## Hidden Creek Estates Subdivision

### Final Plat

#### Letter of Intent

File No.: SF253

CULDESAC STA 1+00.00 TO 4+27.29

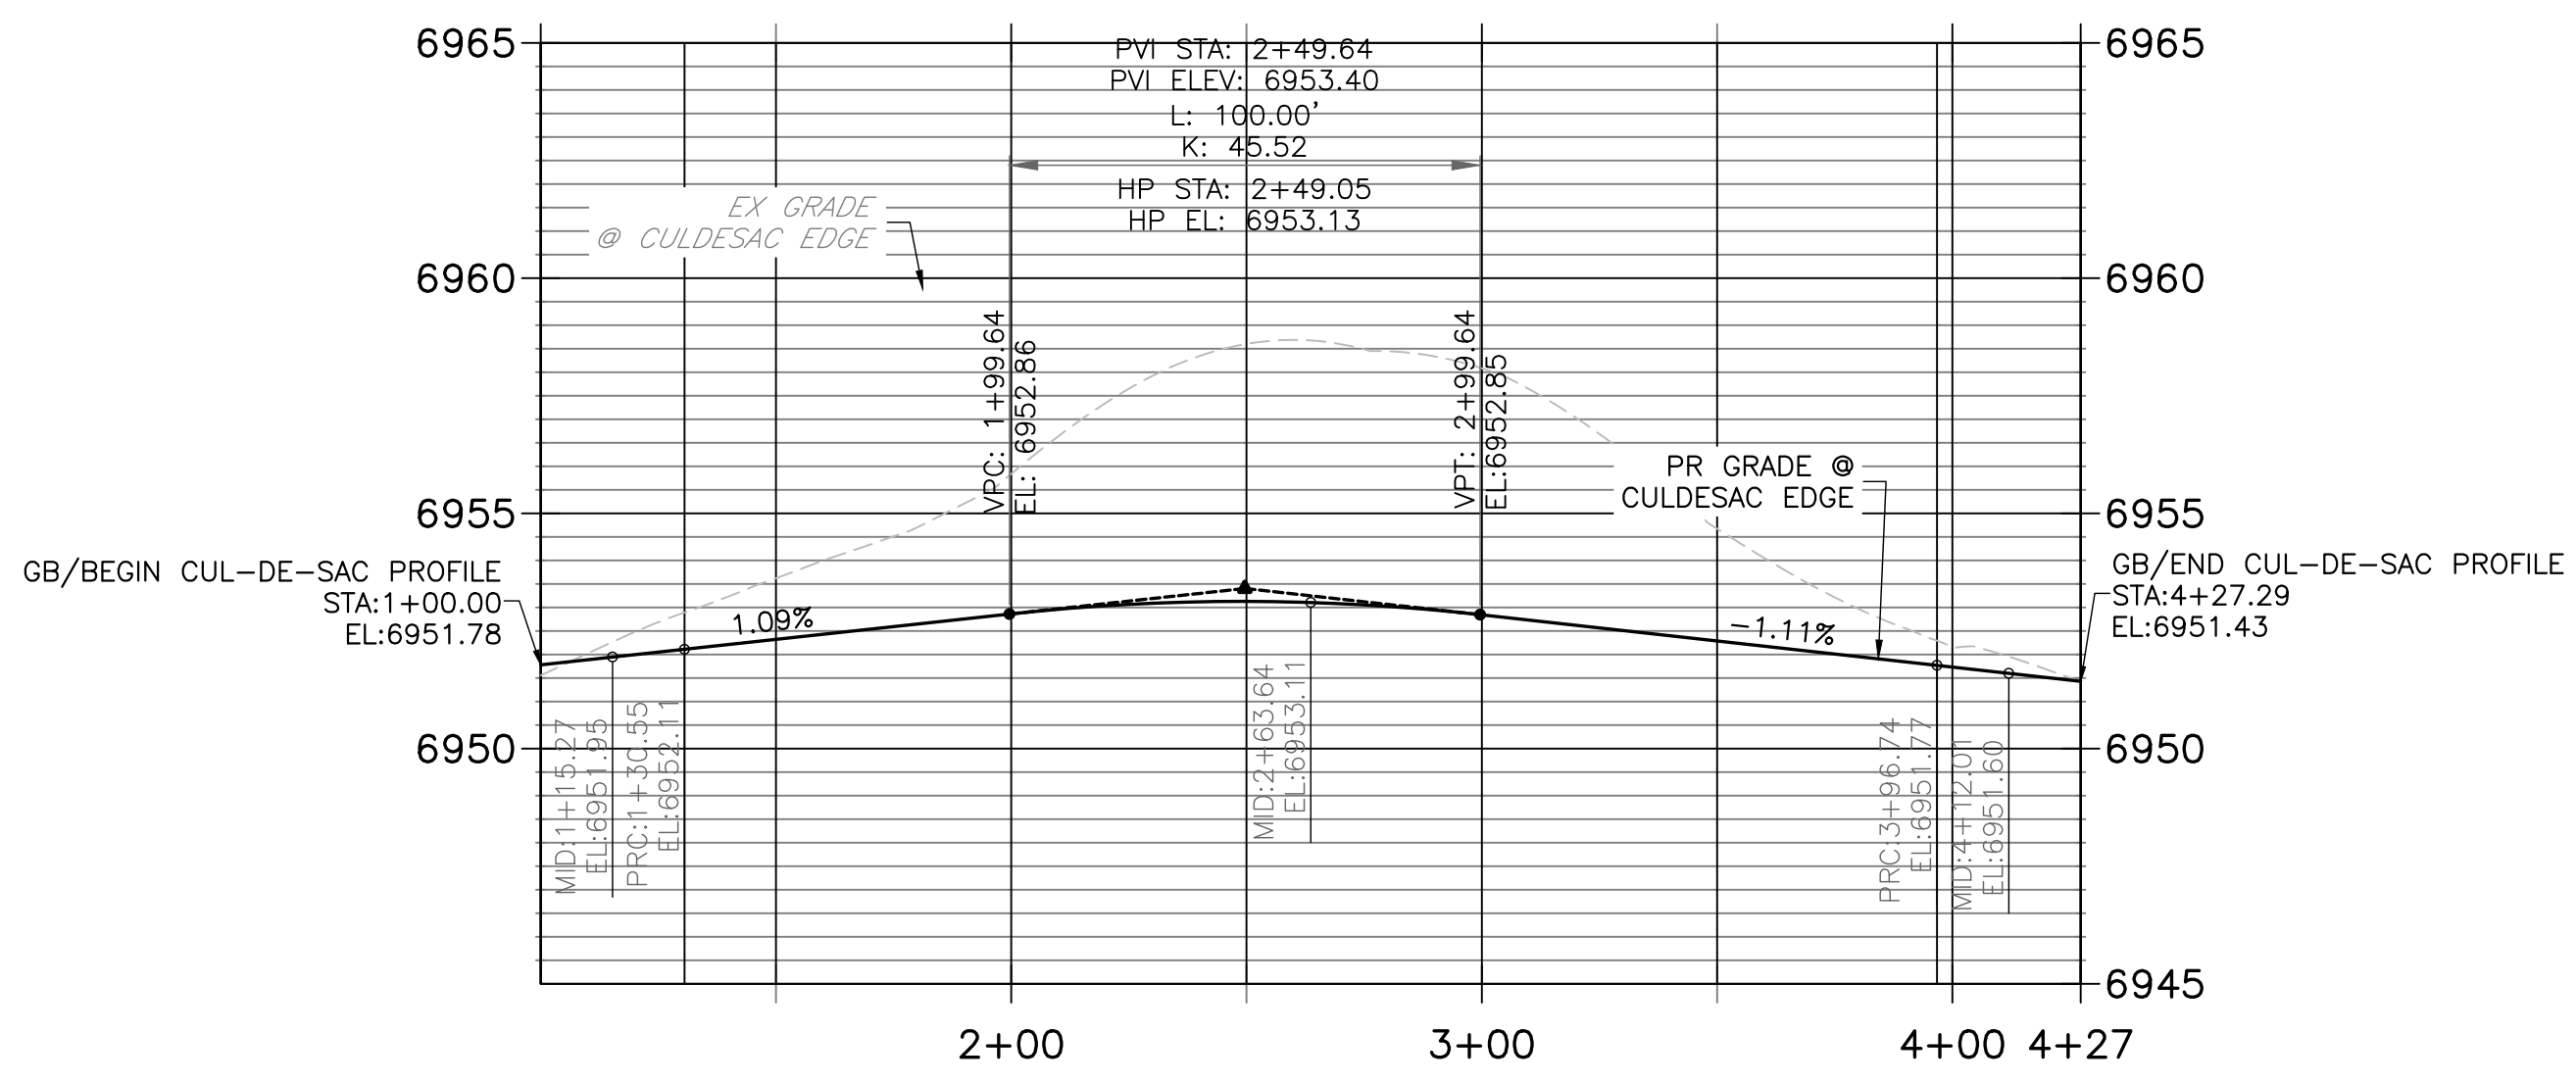
design speed of the private roadway has not been provided.

the grade exceeds ECM criteria. It should be listed that the max grade requested is 12% as shown on the CD's

RESPONSE: design speed added

RESPONSE: added
